From: ELIZABETH FORD [REDACTED]
Sent: 11 June 2012 17:29
To: Siobhan Honney-Bayes
Subject: Fw: Landscape for the Dome, U. of Chichester, Bognor Regis
Dear Siobhan,

From: "Mowatt, Keely" [REDACTED]
To: ELIZABETH FORD [REDACTED]
Sent: Monday, 11 June 2012, 16:24
Subject: RE: Landscape for the Dome, U. of Chichester, Bognor Regis

I have submitted a planning application for landscape works in the gardens of the Dome to Arun District Council. The key issue is the rebuilding of an old wall which requires permission and is shown as being within the flood zone. Arun DC have said that they may require a flood risk assessment for this area.

Dome Building, University of Chichester Replacement Wall

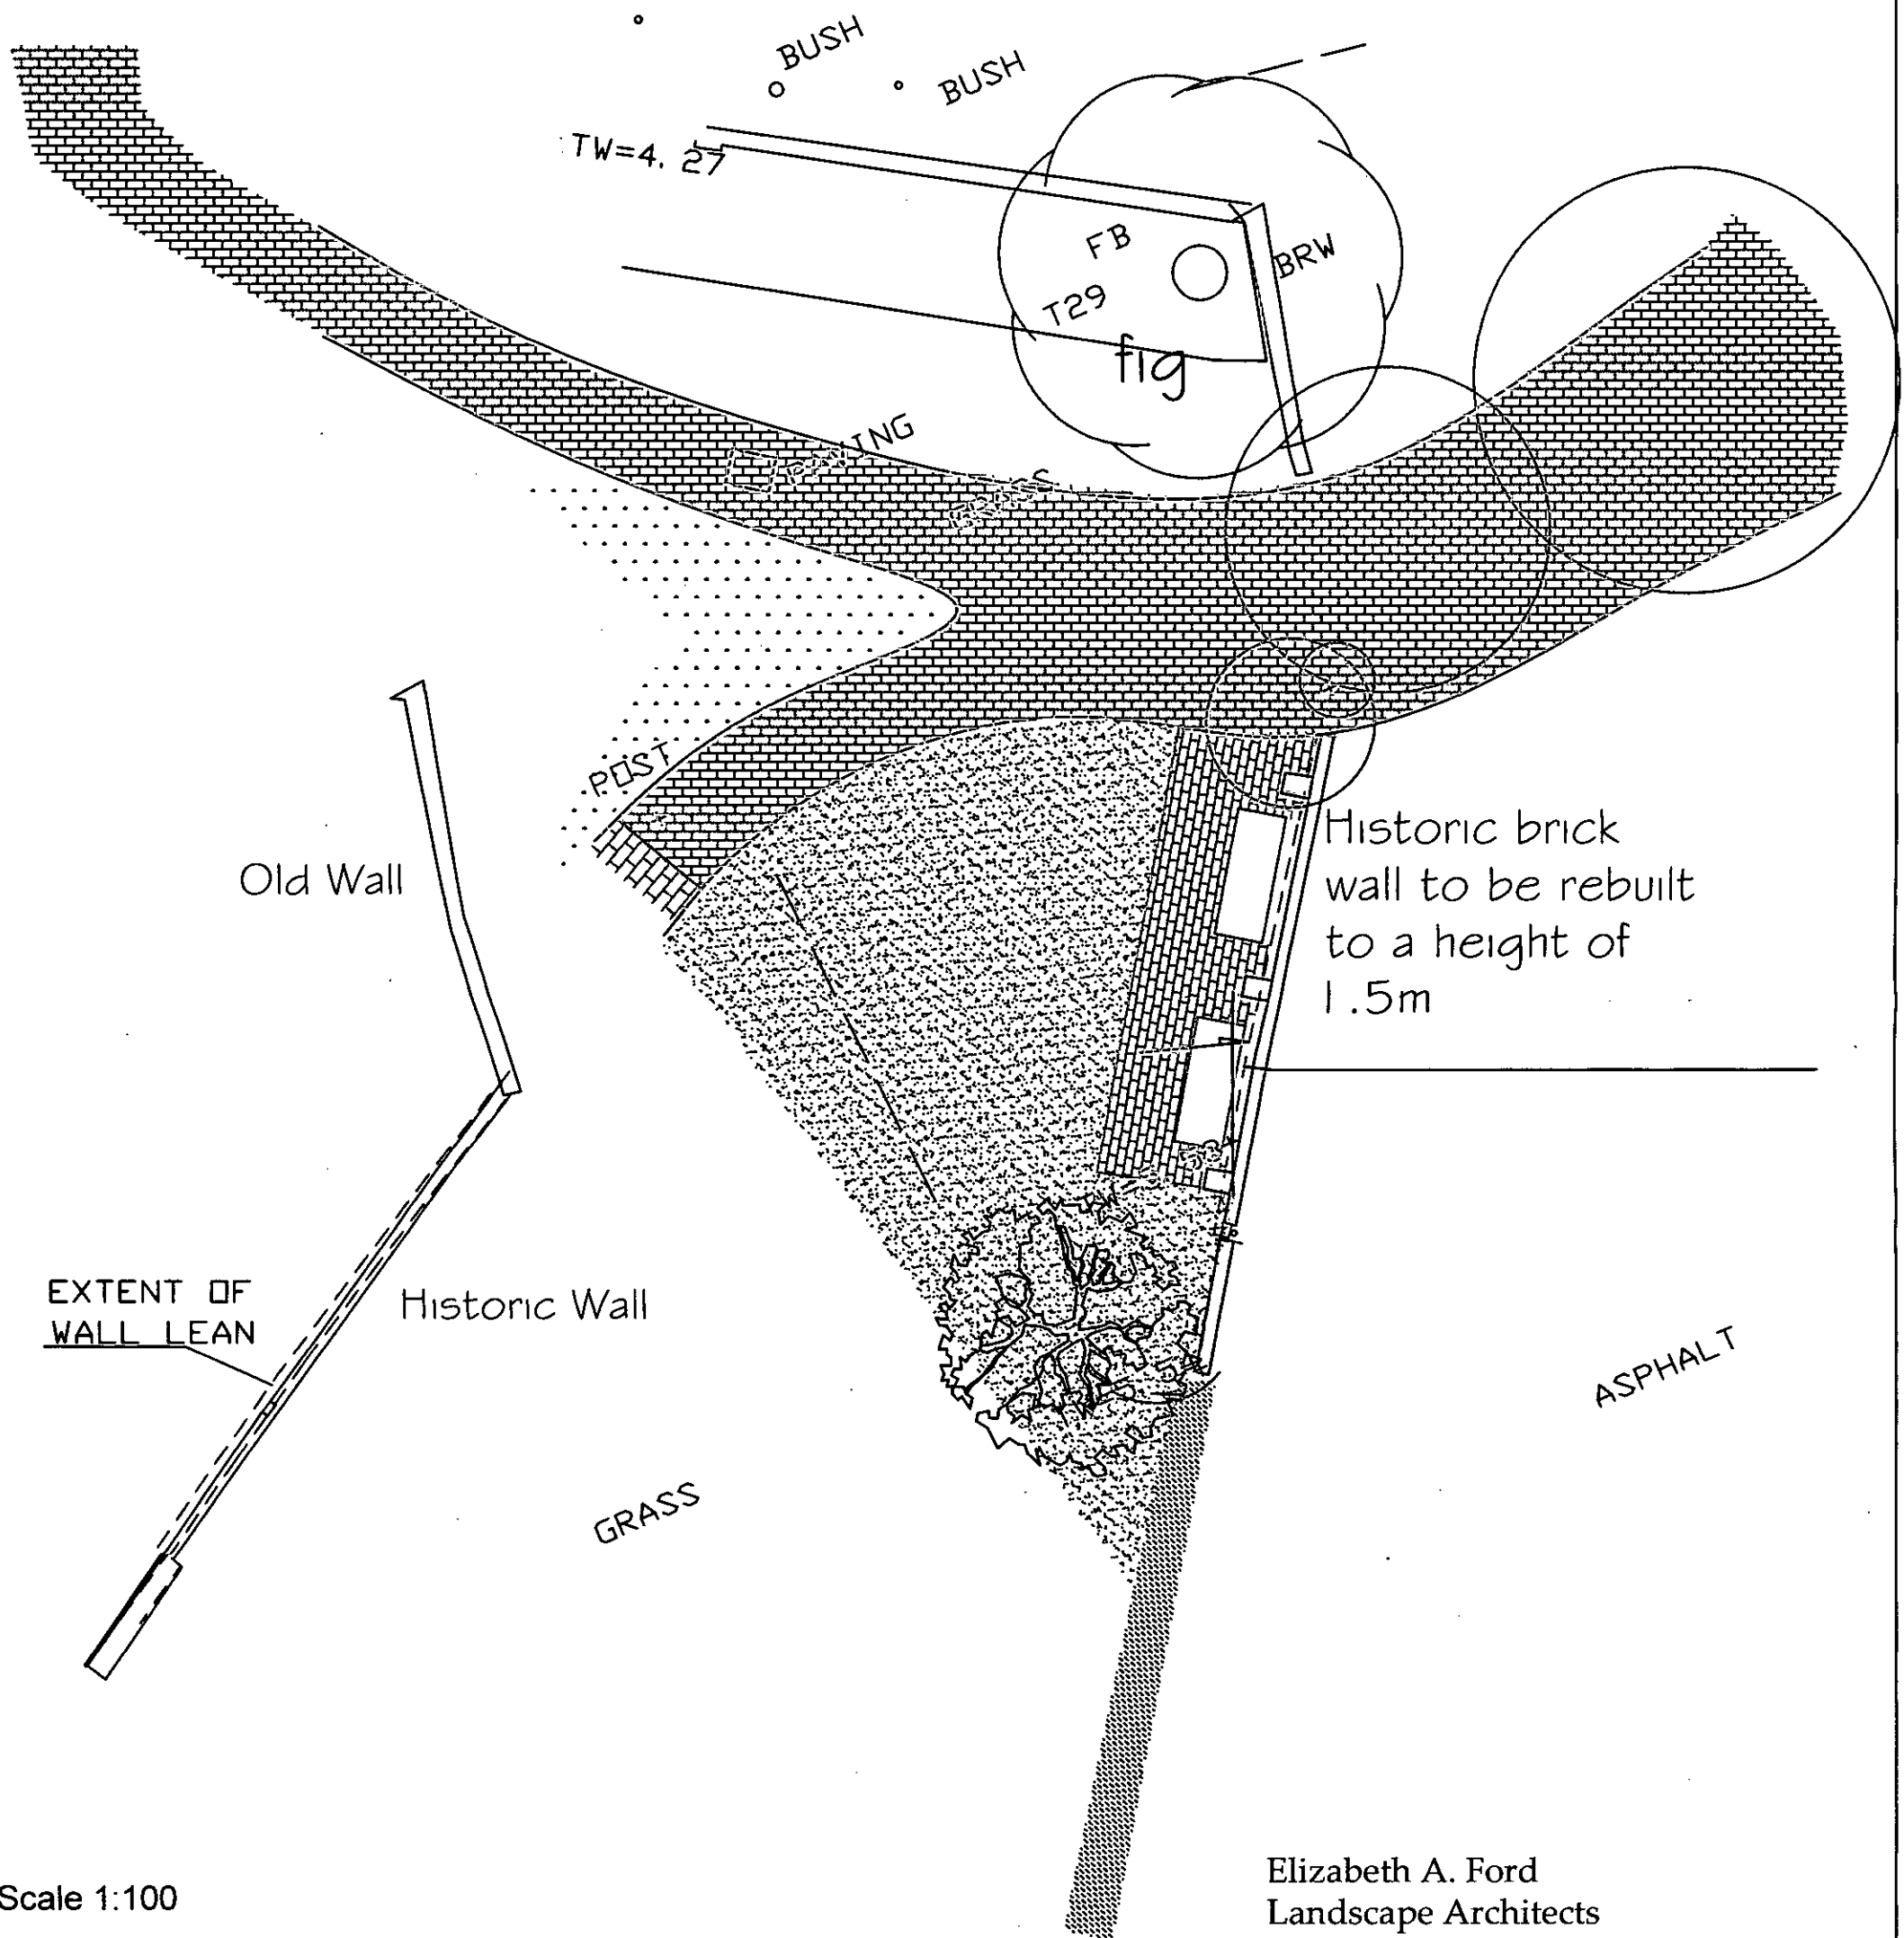
Although within a flood risk area, your proposal to rebuild an existing wall is very minor and we do not consider that it poses an increase to flood risk. Therefore in this instance we do not feel a flood risk assessment is necessary.
